**EL PASO COUNTY PLANNING AND
 COMMUNITY DEVELOPMENT
 DEPARTMENT**

GRADING AND EROSION CONTROL PLAN CHECKLIST

Carriage Meadow South 2

STORMWATER MANAGEMENT PLAN CHECKLIST

**NOTE:**  
HOME BUILDER OR  
CONTRACTOR SHALL AS-BUILT  
ALL IMPROVEMENTS PRIOR TO  
CONSTRUCTING ANY  
BUILDINGS. THE ENGINEER  
SHALL BE NOTIFIED OF ANY  
DISCREPANCY FROM THIS  
PLAN PRIOR TO ANY BUILDING  
CONSTRUCTION.

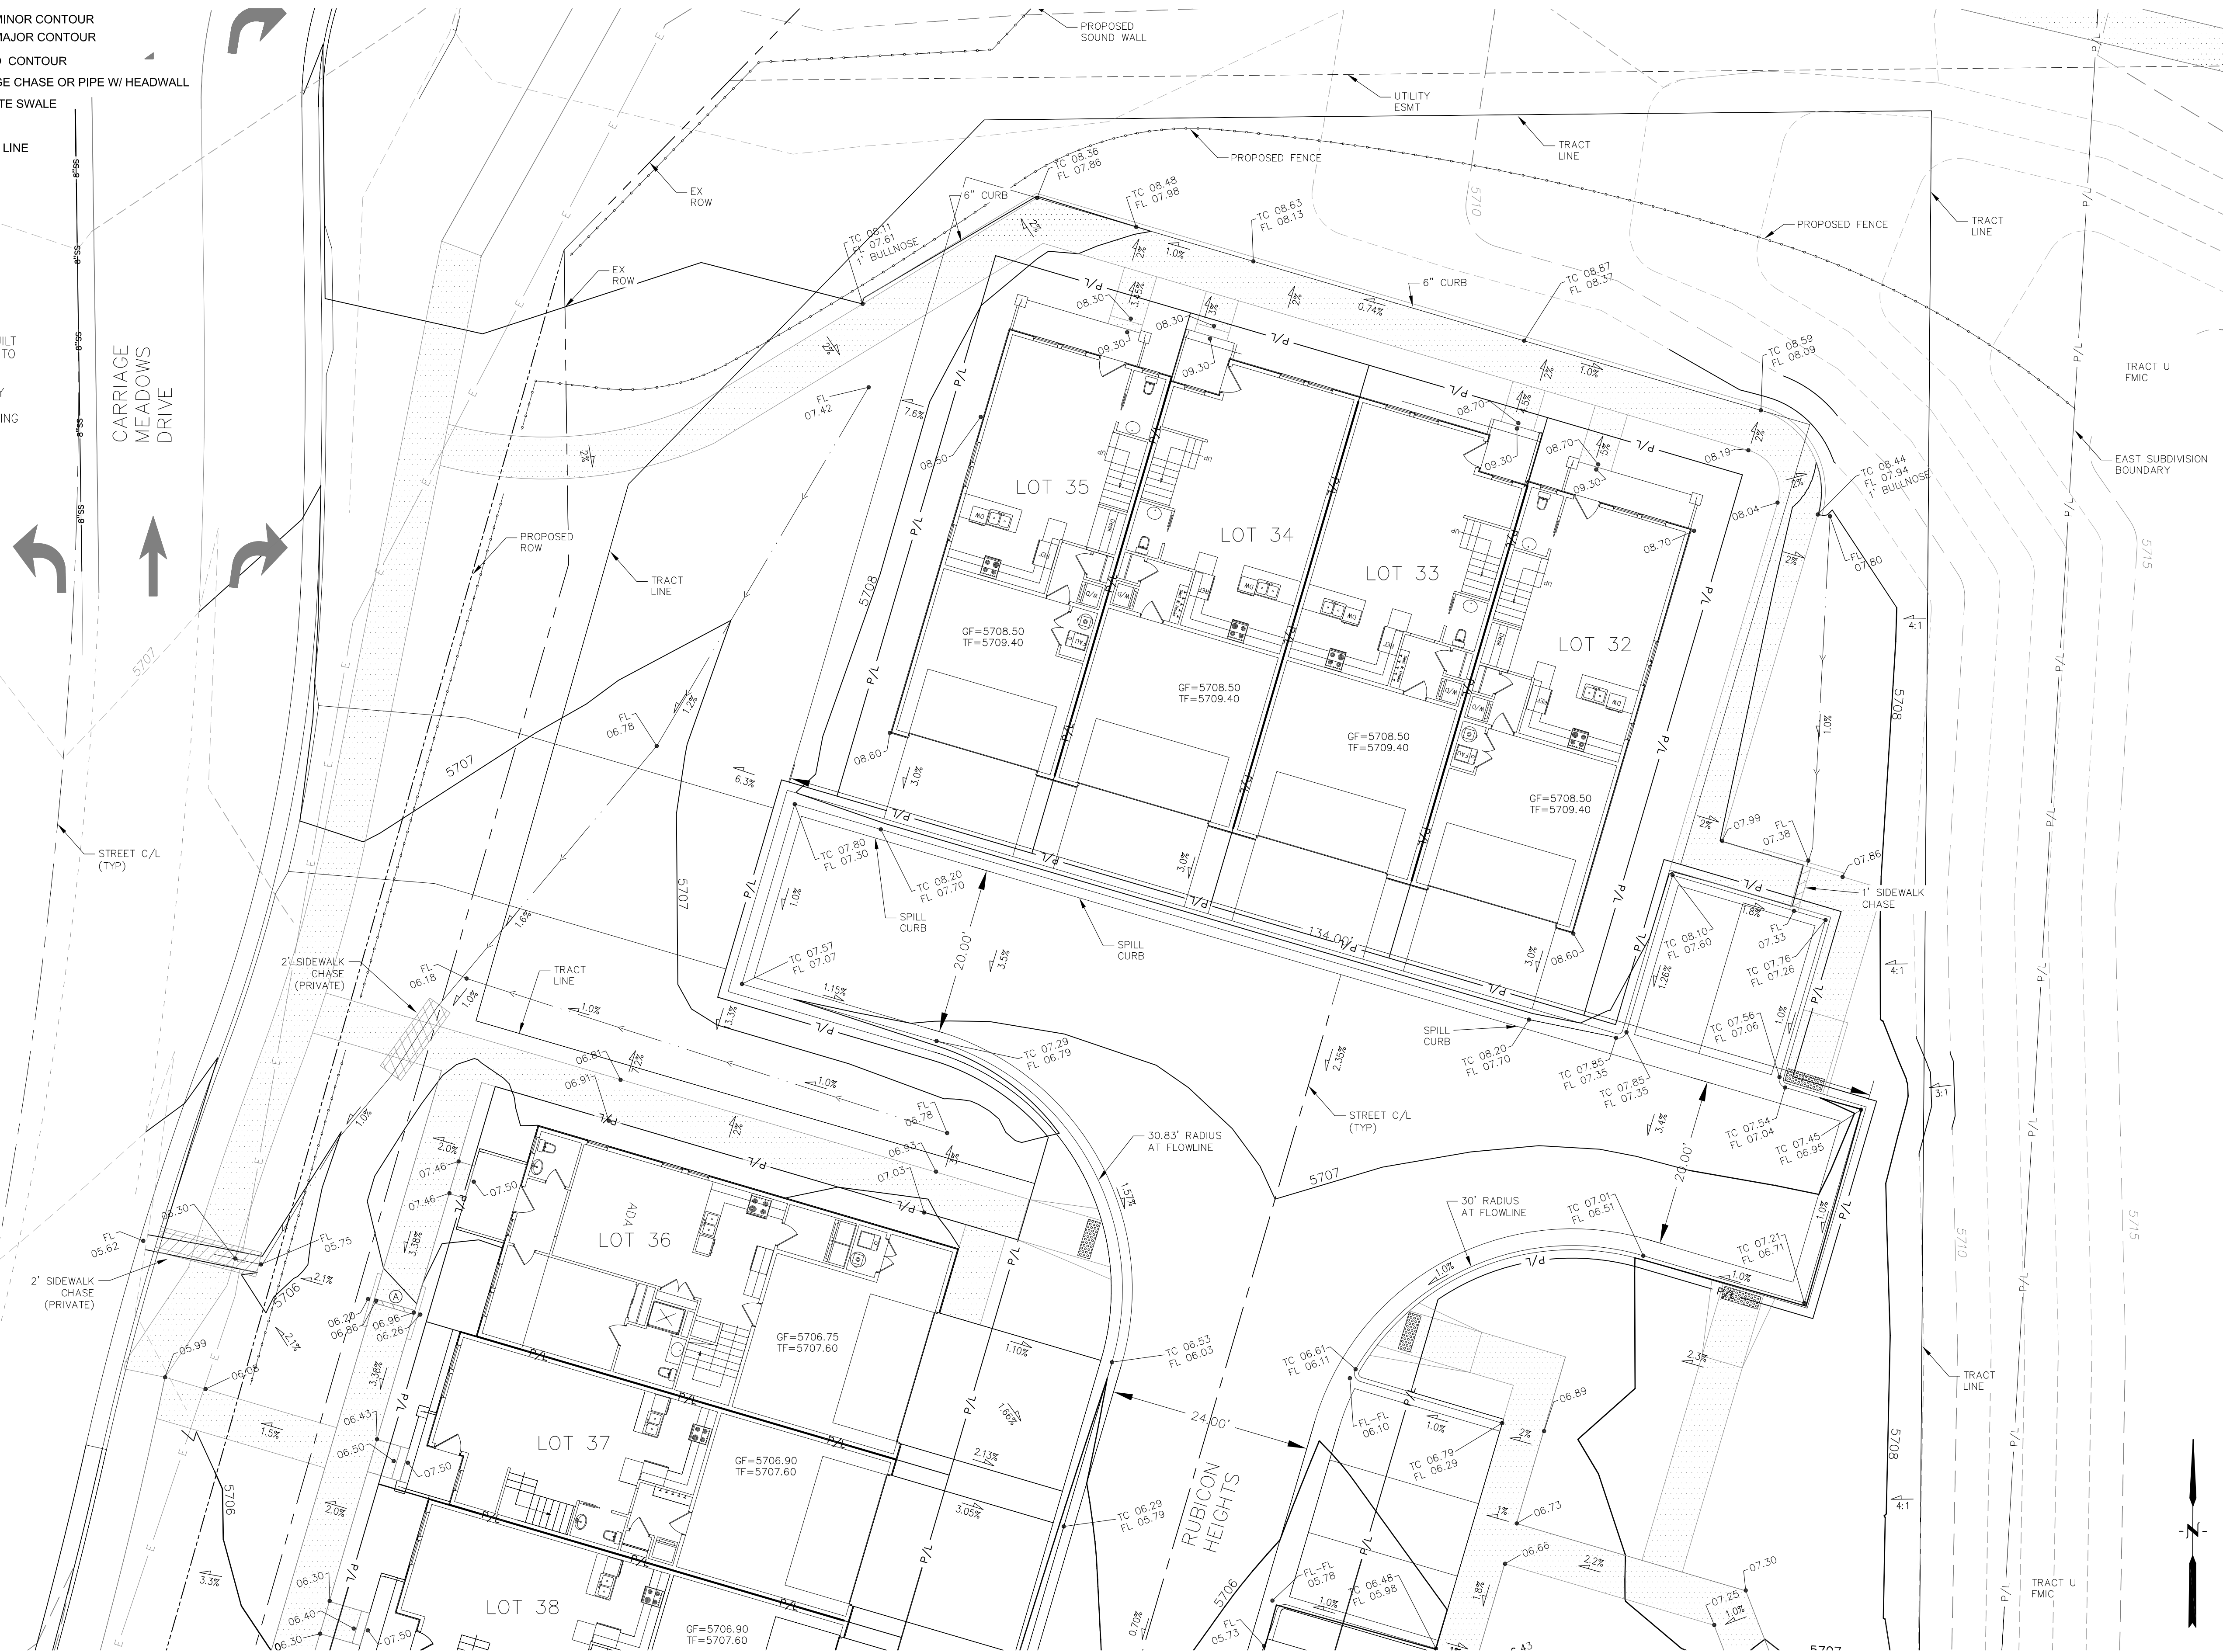
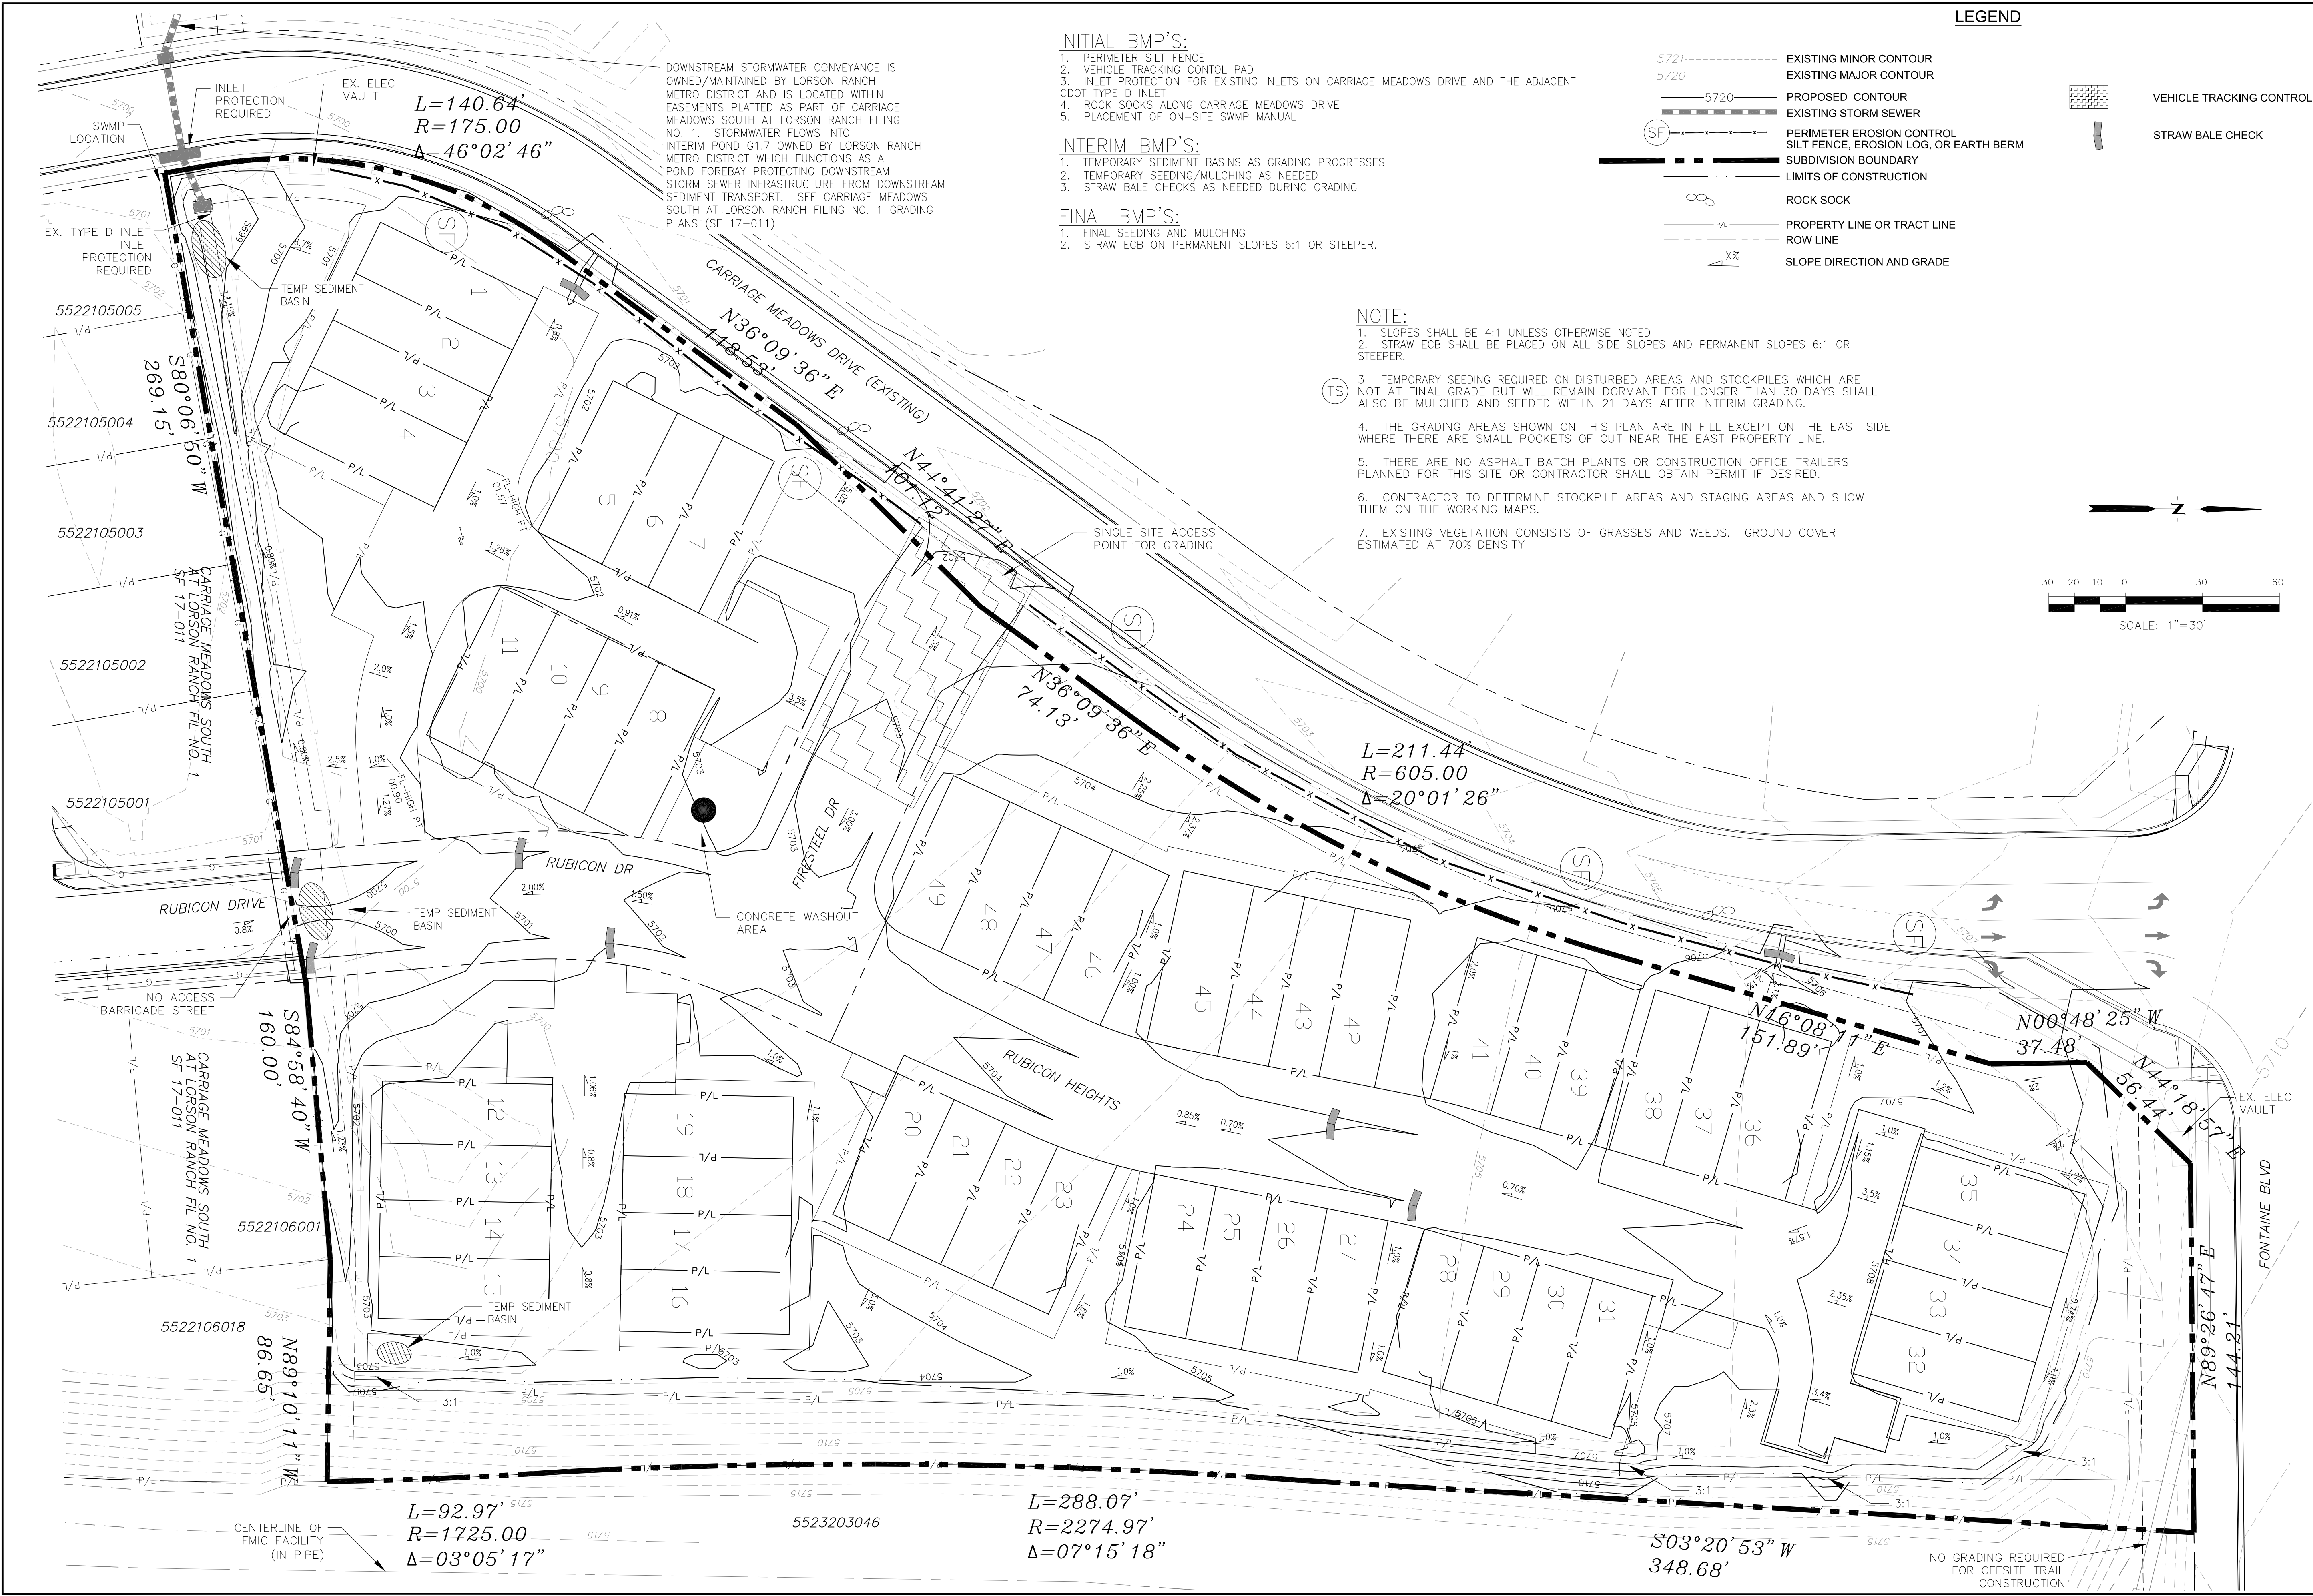
l	Existing and proposed contours 2 feet or less (except for hillside). <i>existing contours should be updated to the current grades for this GEC plan</i>	y	X
m	Limits of disturbance delineating all anticipated areas of soil disturbance.	y	✓
n	Identify and protect areas outside of the construction site boundary with existing fencing, construction fencing or other methods as appropriate.	y	✓
o	Offsite grading clearly shown and called out.	n/a	N/A
p	Areas of cut and fill identified. (See Notes)	n/a	N/A
q	Conclusions from soils/geotechnical report and geologic hazards report incorporated in grading design (slopes, embankments, materials, mitigation, etc.)	y	✓
r	Proposed slopes steeper than 3:1 with top and toe of slope delineated. Erosion control blanketing or other protective covering required.	y	✓
s	Stormwater flow direction arrows.	y	✓
t	Location of any dedicated asphalt / concrete batch plants. (see notes)	n/a	N/A

4. Applicant Comments:			
a	cut/fill areas not needed since entire site is in fill except for small area on east side. Note added to plan		
b	No asphalt batch plans. Note added to plans.
